**From:** Nick Goddard  
**Sent:** 29 March 2017 09:51  
**To:** DCAdmin  
**Subject:** 2017/90661 PC Westfield Assessment Centre

The proposed layout and reduced number of plots is generally a great improvement on previous submissions however I have some concerns which are detailed below:

FLOOR PLAN
PLOT 12

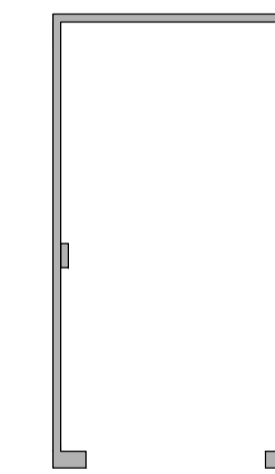
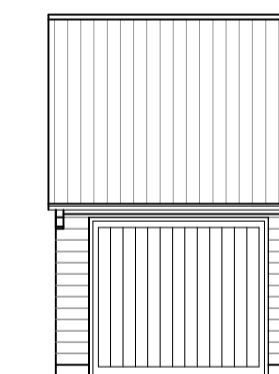
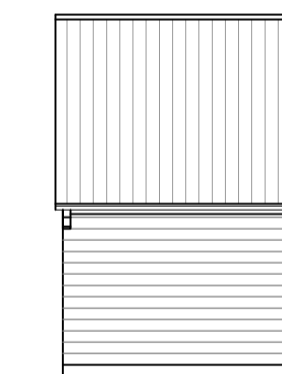
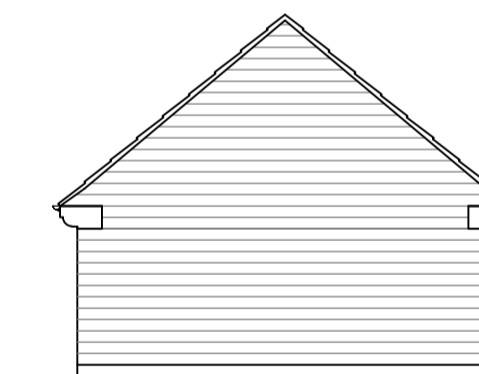
1. Plot 12 is positioned within the shade of several large mature trees and consequently would lead to a pressure to prune or fell these protected trees in the future.
2. The drive way and garages for plots 10, 11 & 12 are substantially within the rooting area of two category A trees ( 1.28 & 1.33) and one category B tree (1.31)
3. No tree protection fencing has been shown around two of the most visually prominent trees within the site (2.16 & 2.17). No reason is given for this in the Method Statement provided nor can I think of any reason where this would be acceptable.

- Re-designing Plot 10, 11 & 12 and adjacent visitor parking could remove all of these concerns.
- Amending the Tree Protection Plan to show fencing around all retained trees.
